From: clerk@longridge-tc.gov.uk
Sent: 18 May 2023 14:05
To: Planning
Subject: 3/2023/0092 53-57 Berry Lane, Longridge PR3 3NH

Longridge Town Council Comment:

title
Proposed
External Elevations

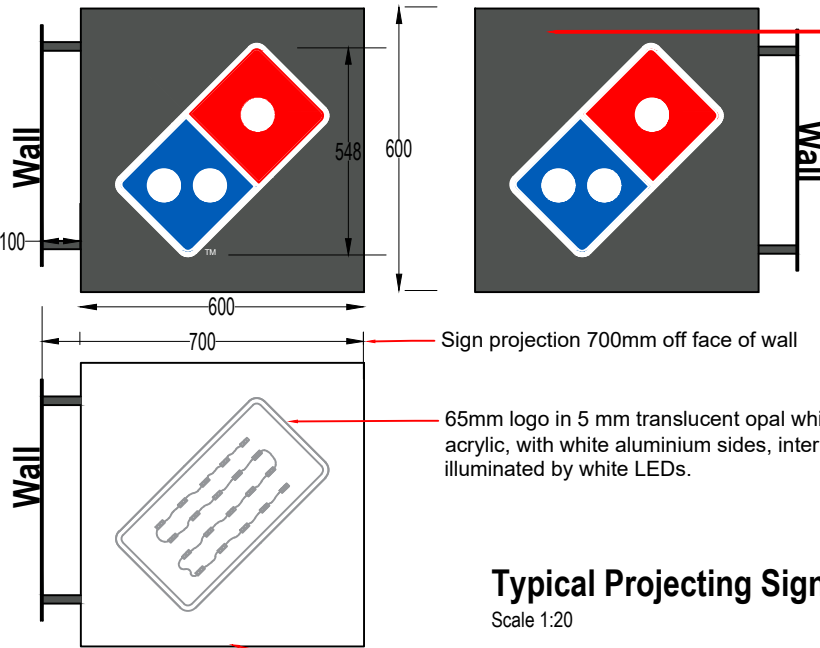
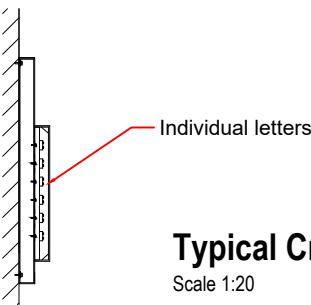
Longridge Town Council express concerns regarding the illuminated sign.

The property on which the sign is located does lie within a conservation area; this is relevant in applying the provisions of the Town and Country Planning (Control of Advertisements) Regs 2007 as amended.

With reference made to Ribble Valley Borough Council's guidance for outdoor advertisement and signs information 'Advertisements must not be illuminated or displayed within one metre of any window or other external opening through which they can be seen from the outside of the building'. This planning application goes against RVBC guidance and raises concerns that a precedent will be set for future and past applications which have been objected to.
